Ribble Valley Borough Council  
Housing & Development Control

Application no: **3/2020/0981**

Address: **Land at Moran's Farm Pendleton Road Wiswell Clitheroe BB7 9BZ**

Proposal: **Proposed change of use of land for the siting of four holiday lodges with associated parking, access and amenity areas.**

Scale(s) 1:200 @ A1 Date OCTOBER 2020
 Drawing no. ADM/20/34/01 Rev.

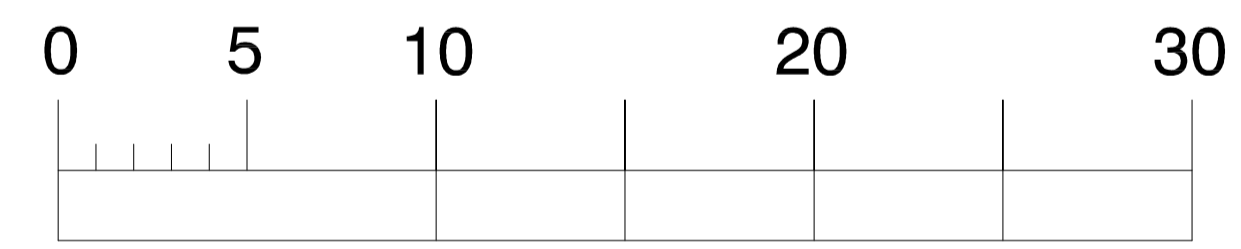
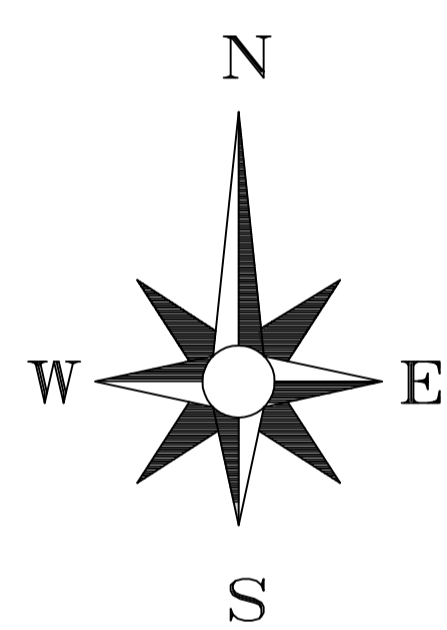
Having received the requested speed data and revised plan (drawing number ADM/20/34/01 Rev C) which incorporates the visibility splays required from the provided 85<sup>th</sup>ile speed data, as well as the other initially raised concerns I can confirm that the proposed site layout is considered acceptable in terms of highway safety.

- 4. No building (or use hereby permitted) shall be occupied (or use commenced) until visibility splays 2.4 metres back from the centre line of the access and extending 35m metres on the nearside carriageway edge in both directions have been provided, as shown on the approved plans. Nothing shall be erected, retained, planted and / or allowed to grow at or above a height of 0.9 metres above the nearside carriageway level which would obstruct the visibility splay. The visibility splays shall be maintained free of obstruction at all times thereafter for the lifetime of the development.
